September 8, 2016

RE: **Covered Wagon**  
**13609 Covered wagon Ave.**  
**Grading and Drainage Plan**  
**Engineers Stamp Date 8/29/16 (L23D014)**

Based upon the information provided in your submittal received 8/31/16, this plan is approved for Grading Permit and Building Permit.

COVERED WAGON SUBDIVISION - LOT 15	DRAWN BY WCKJ
	GRADING AND DRAINAGE PLAN	DATE 7-29-16
		21511-LAYOUT-4-02-15
		SHEET #
DAVID SOULE P.E. #14522		JOB # 21510

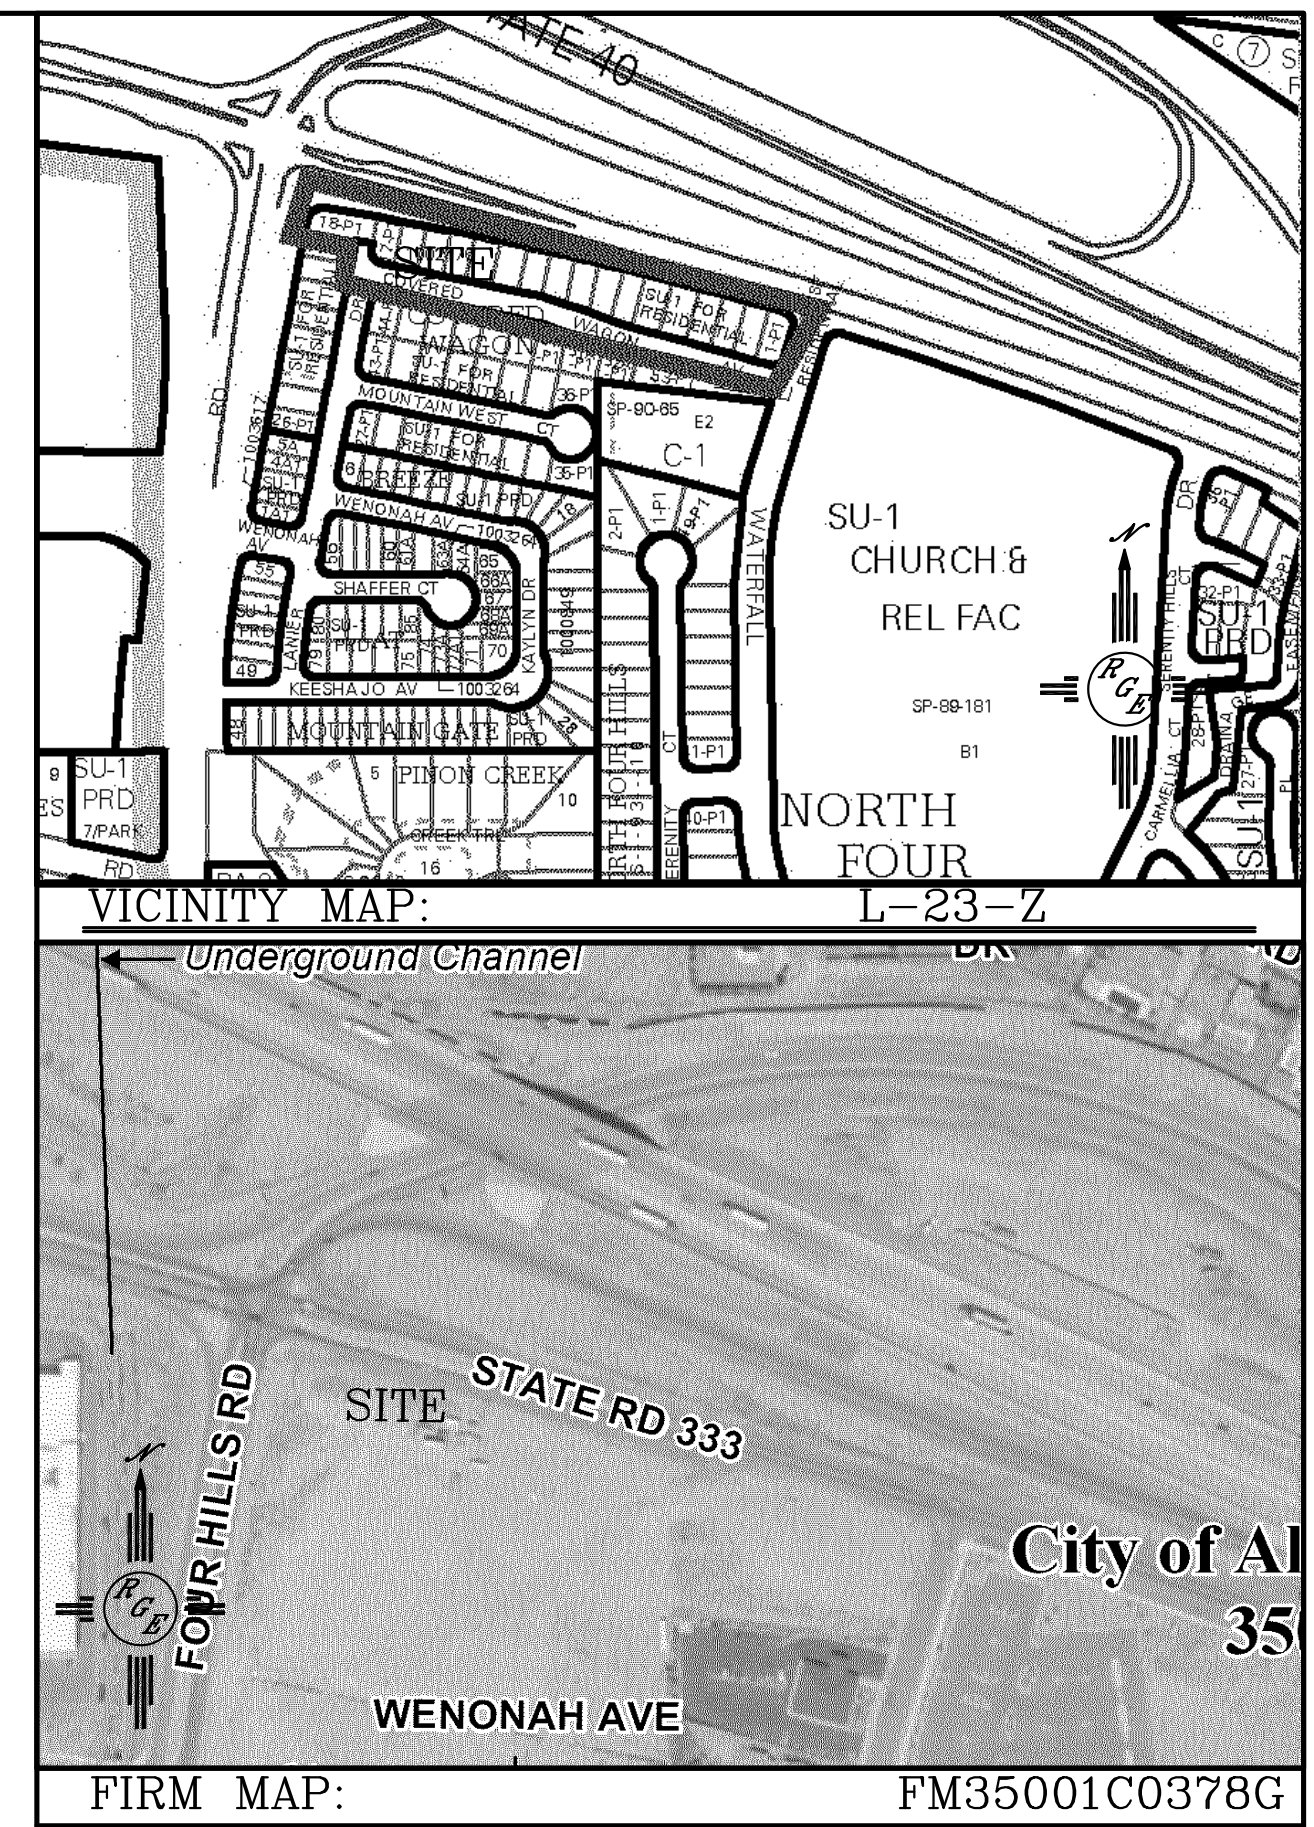
- An approved ESC plan is required for all the lots, plus an ESC Permit is required for each lot which have different owners.  
An ESC has been approved
- Address the First Flush requirements. All flows must exit the front yard via a landscaped pond.  
The first flush volume has been shown and pond added to the plan
- Provide how erosion will be prevented from entering the adjacent property.  
Note number 4 has been added to the plan to address the conformance to the ESC
- Provide an excerpt about the retaining wall in the rear yards. Who will be responsible for the maintenance of the retaining wall?  
As discussed on the phone, the wall was constructed under work order
- Was the retaining wall in the rear yards approved and certified?  
The wall was approved and certified under previous work order.
